## PLAN SNAPSHOT REPORT SP-2025-00066 FOR CITY OF ALBUQUERQUE

<b>Plan Type:</b> Site Plan	<b>Project:</b> PR-2021-005714 (PR-2021-005714)	<b>App Date:</b> 08/29/2025
<b>Work Class:</b> EPC	<b>District:</b> City of Albuquerque	<b>Exp Date:</b> 08/28/2028
<b>Status:</b> Fees Due	<b>Square Feet:</b> 0.00	<b>Completed:</b> 09/08/2025
<b>Valuation:</b> \$0.00	<b>Assigned To:</b>	<b>Approval Expire Date:</b> 09/06/2032
<b>Description:</b> Discount Towing Facility - Submission to the EPC for site plan approval		
Parcel: 101406050923542201 Main	Address: 4000 2Nd St Nw 4000 2Nd St Nw Albuquerque, NM 4000 2Nd St Nw Albuquerque, NM 87107	Zone:

SOLID WASTE SITE PLAN
1 A1.3

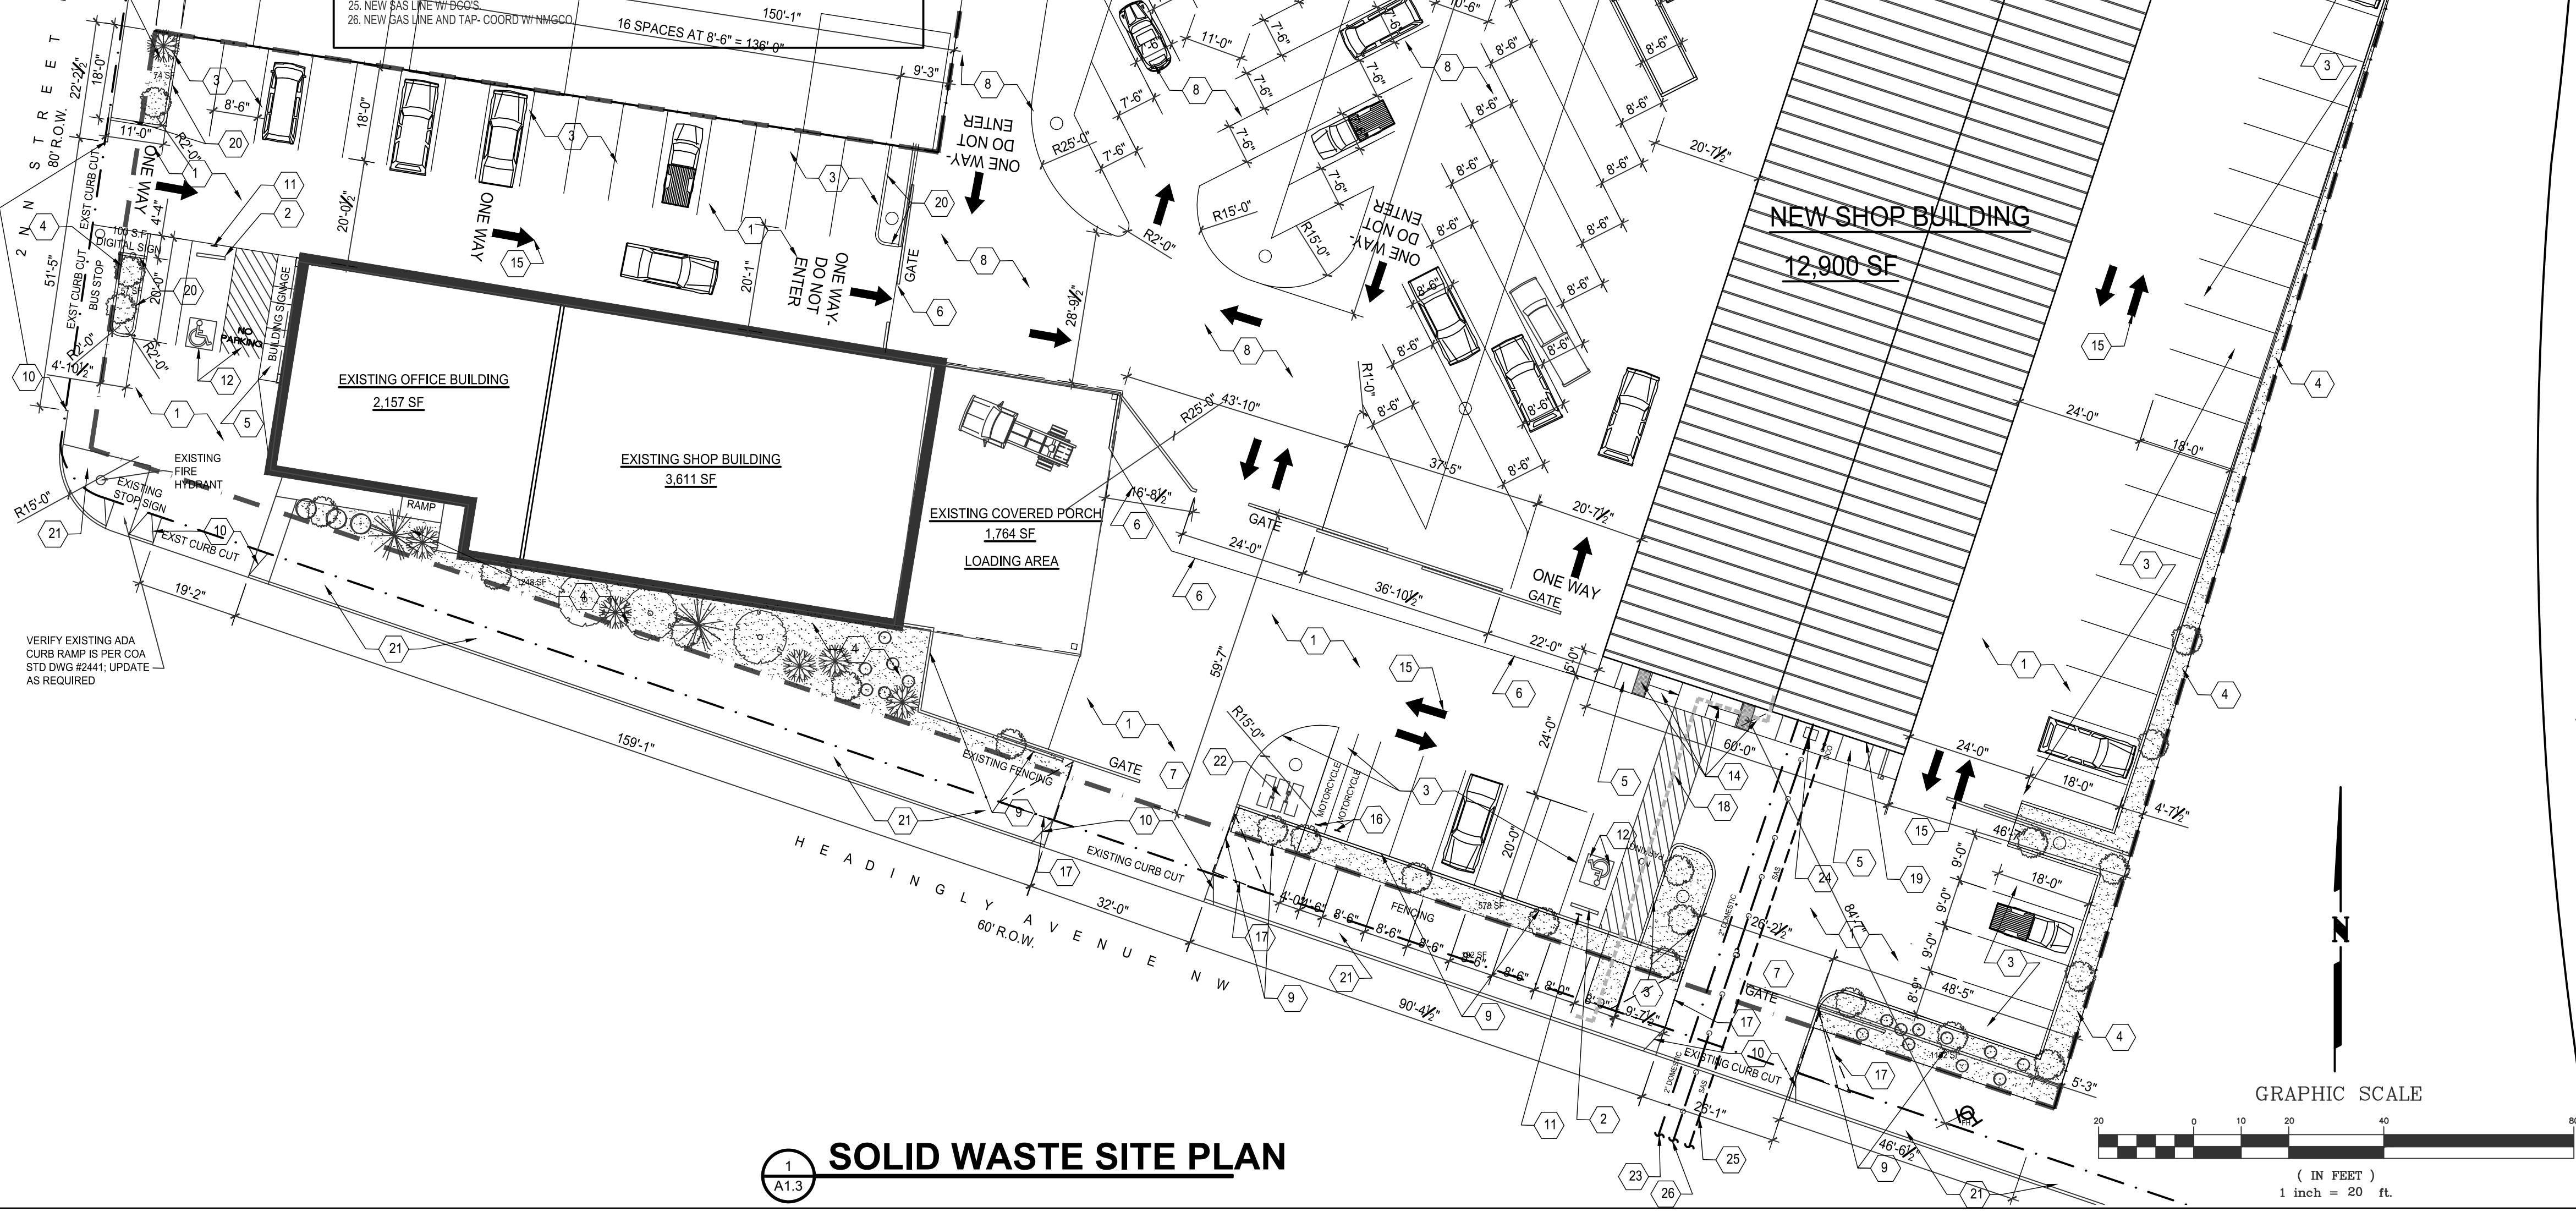
Item Review Name	Department	Assigned User	Status	Assigned Date	Due Date	Completed Date
Solid Waste	Solid Waste	Marez, Adrian	Comments Given/No Comments	09/09/2025	09/29/2025	09/12/2025
<b>Comments:</b> SITE PLAN TO SCALE WILL NEED TO BE PROVIDED WITH ALL DETAILS TO AMAREZ@CABQ.GOV FOR APPROVAL FOR ACCESS TO REFUSE SERVICE. TRASH ENCLOSURE MUST MEET MINIMUM COA SOLID WASTE REQUIREMENT
